Application No: AW/133/22/HH
Site Address: 15 The Fairway Aldwick PO21 4ES
Description of works: Erection of single storey side extension including separate porch following demolition of existing side extension. This application may affect the character and appearance of the Aldwick Bay Conservation Area.

Thank you for your internet representation made on 13th June 2022 which has been recorded as an objection with the comments as follows:

EAST ELEVATION 1

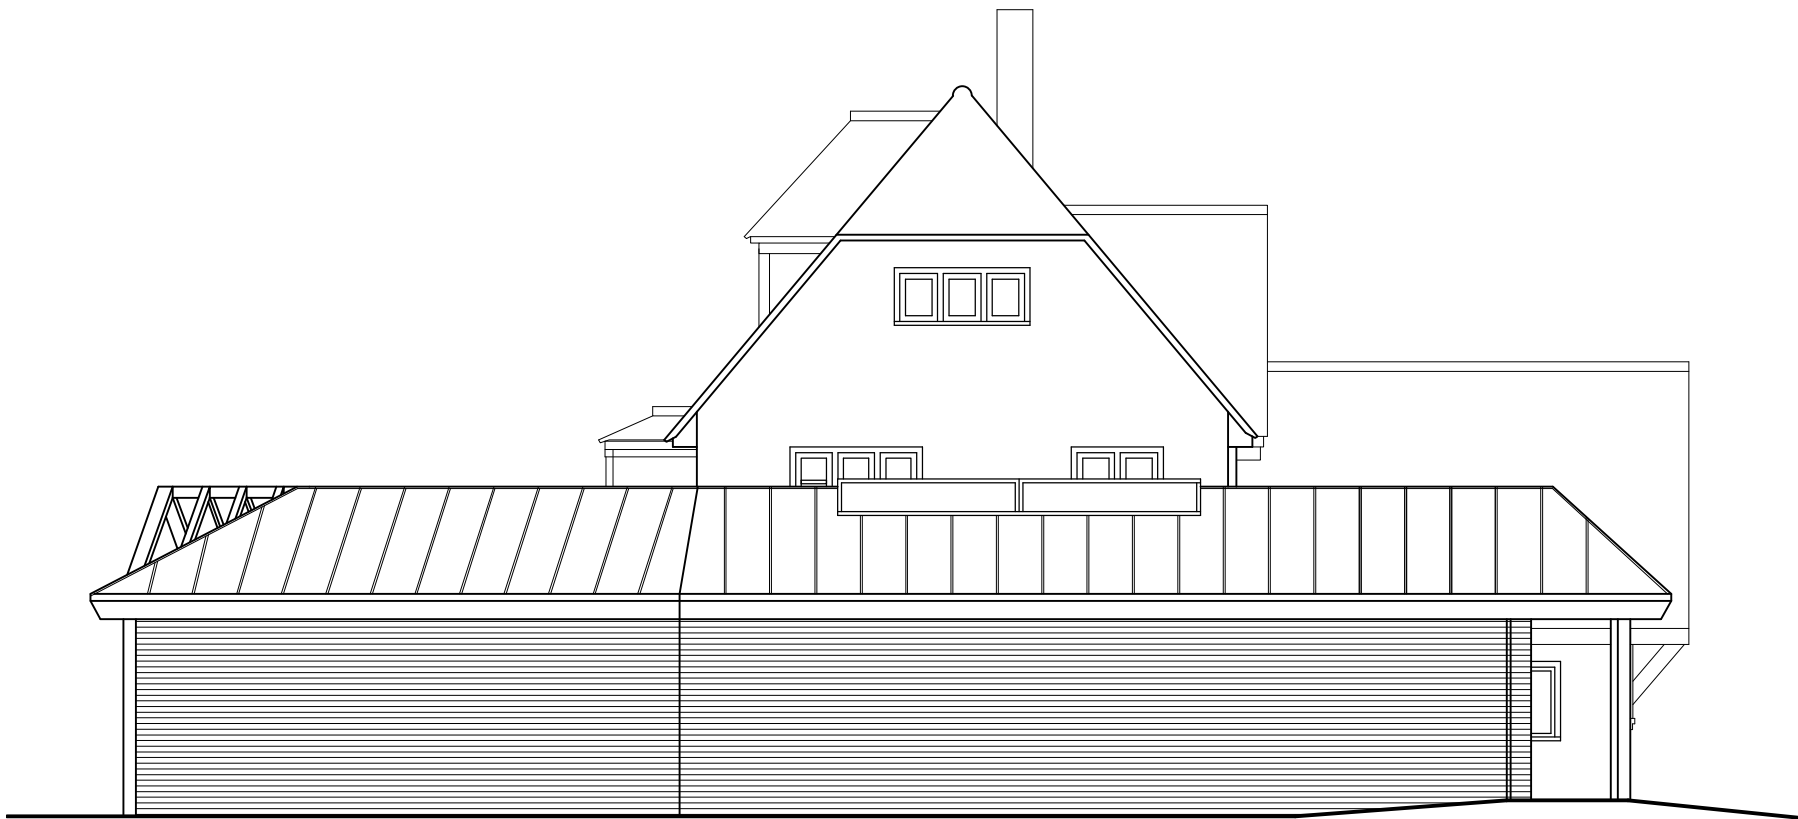
I do not believe that this application should go ahead. The proposed extension will cause serious loss of amenity to No 14. The modern form of the roof which I understand will be in something called pre-patinated zinc is entirely out of keeping with the surrounding area. Thank you
